From: HUTCHINS MICHAEL [REDACTED]
Sent: 04 March 2013 16:47
To: Janice Chapman
Subject: Re: BR/129/11 - Replacement first floor bay to front elevation and installation of additional second floor bay to match, Langford House, 7 The Steyne, Bognor Regis

In response to your subsequent e-mail of 4th March in respect of the above planning approval BR/129/11 the approved drawings show a flat roof.

SCHEMATIC OF ASSEMBLY RE: BALCONIES
AND SUNSPACE AT LANGFOLD HOUSE,
THE STEYNE, BOGNOR REGIS.

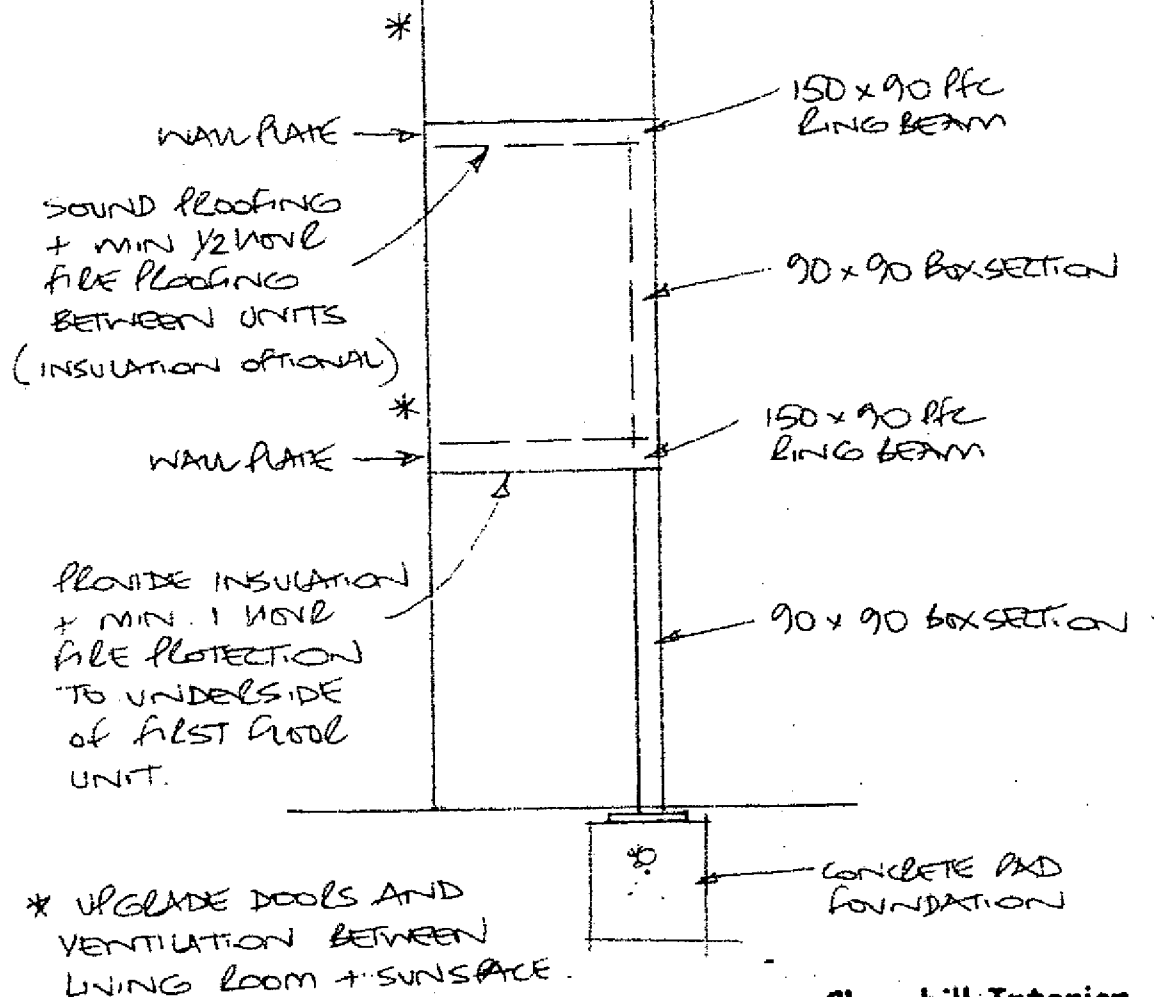
The 3rd paragraph was referring to the Churchill Interior Finishing Limited drawing not to the CAD drawing with three windows which is not acceptable.

I have viewed the submitted drawings and the revision to the roof detail would be acceptable. However, the drawing of the bay window and elevations do not accord. The existing windows have two panels of glazing to the front which has been approved and the drawing has three panels of glazing. This would be totally out of keeping with the existing design of the windows on the host building and would require the submission of a new planning application. I have spoken to the Conservation Officer, Mr White who informs me that to preserve and enhance the Steyne Conservation Area we are requesting that any wooden windows be replaced like for like in details and materials. If an application were to be received for the three panel windows then it would be likely to be refused. It should be noted that as the property is flats then any replacement of windows in the building which should be like for like in design would require the submission of a planning application as flats have no "Permitted Development".
